**Consultation Response from KC,
Highways Development Management**

2025/92557 rear of, 66, Child Lane, Roberttown, Liversedge, WF15 7QG

Discharge of details reserved by condition 13 (surfaced and drained areas) on previous permission 2021/91150 for erection of 4 detached dwellings

Drawing Title
PROPOSED SITE LAYOUT

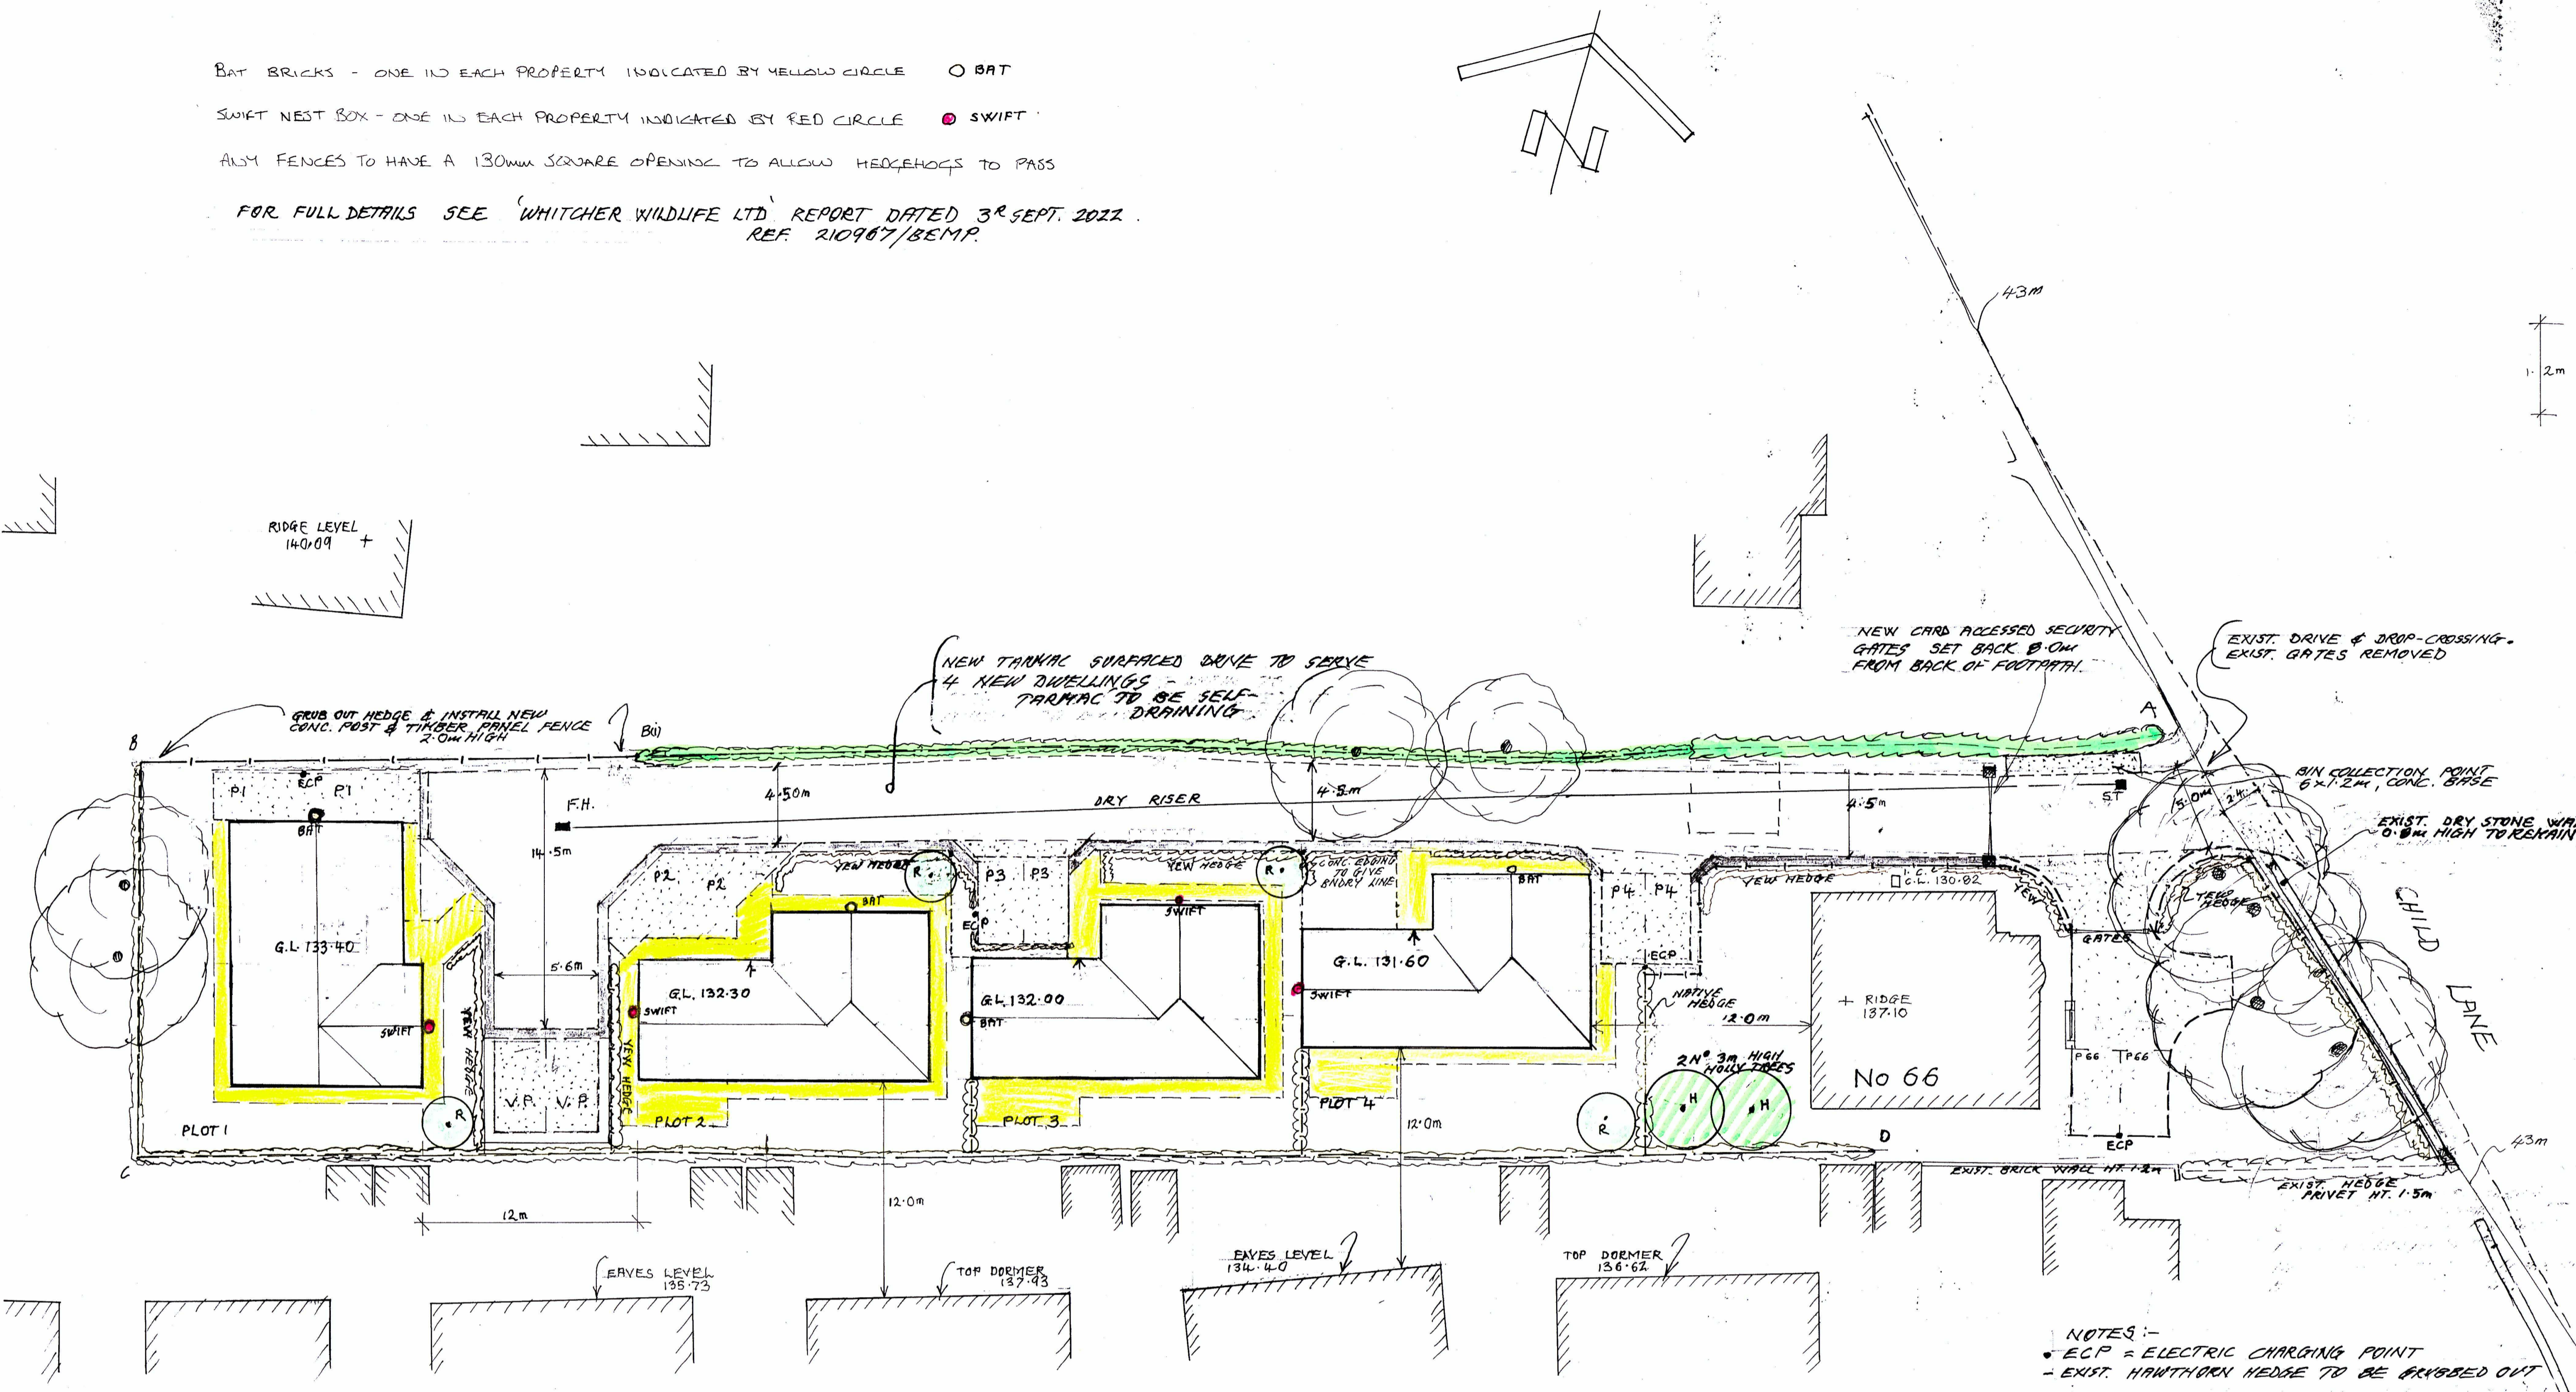
Drawing No 20/207/4 Rev C Proposed Site Layout shows that the vehicular/pedestrian areas serving the 4 new dwellings are to be surfaced with a self-draining tarmac. The covering letter confirms this adding that the self-draining tarmac surfacing is permeable. The surfacing details have been approved by Kirklees Building Control.

With this we consider that the details provided are suitable for the discharge of condition 13.
